Application No: Y/10/22/PL
Site Address: Land to the south of Ford Lane and east of North End Road Yapton BN18 0DS
Description of works: Erection of 15 No dwellings (including 4 No affordable units) with associated access, parking, landscaping, drainage and public open space (additional units to those approved under application Y/123/21/PL). This application may affect the setting of a listed building, affects the character & appearance of the Church Lane Conservation area, affects a Public Right of Way and is in CIL Zone 2 and is CIL Liable as new dwellings.

Thank you for your internet representation made on 9th March 2022 which has been recorded as an objection with the comments as follows:

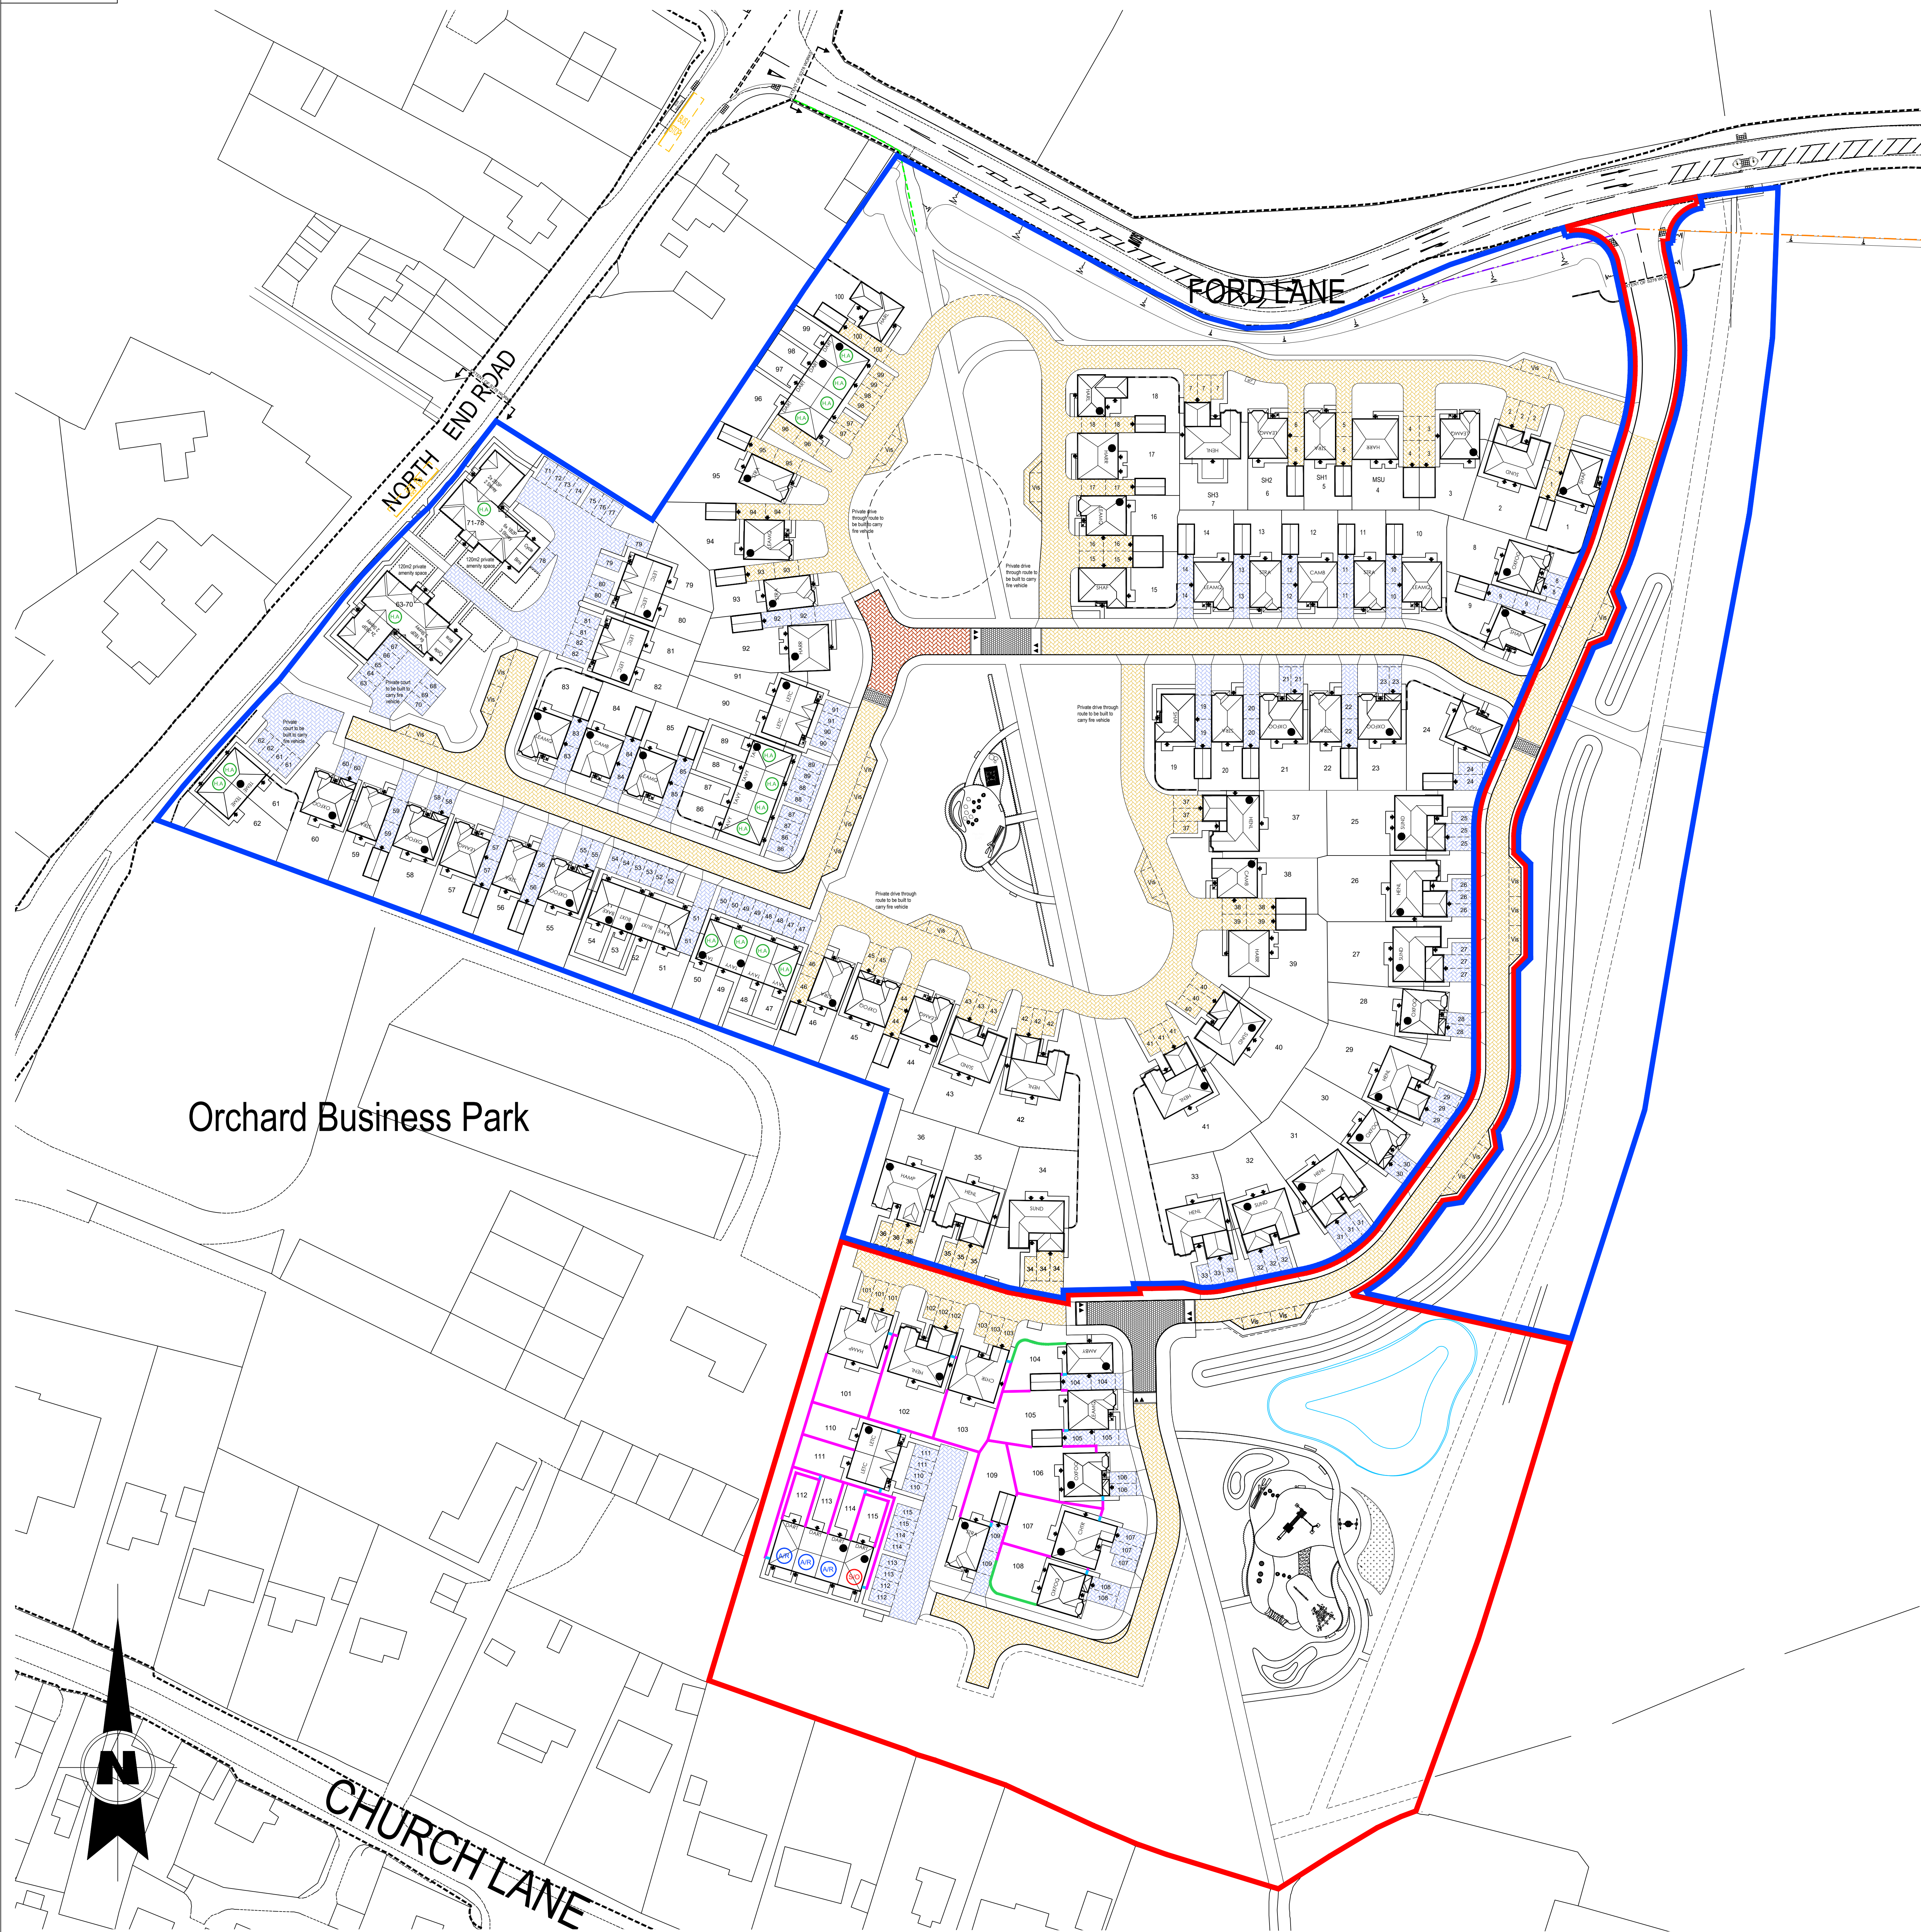
The Western boundary as a whole is given little attention in the application as it is 'bordered by Orchard Business Park'. That simply is not the case for much of the boundary. It borders my house and garden which is sandwiched between this proposed development and Orchard Business Park. The plans and maps that the developers have submitted show my house and garden as part of Orchard Business Park, which is incorrect and misleading.

In the submitted plans, the western boundary line of the site, shown in red, encroaches into my land and the treeline and hedgerows that are claimed as the existing boundary, are my trees and hedgerows. Further, their plans show some trees that are simply not there and cannot be relied upon as a boundary barrier.

Their own drawings show gaps in the existing hedgerow between the development site and my property but no plan is given for the treatment of those gaps other than the vague promise of "a small buffer and boundary hedge". Incidentally, the Ecological Evaluation suggests any such Buffer should be 5 metres wide.

It should also be noted that the house numbered 112, is situated very, very close to an authorised industrial

unit which is frequently noisy. Will the building of these houses lead on to have an adverse impact on the industrial activities of Orchard Business Park and the established local employment opportunities associated therein?
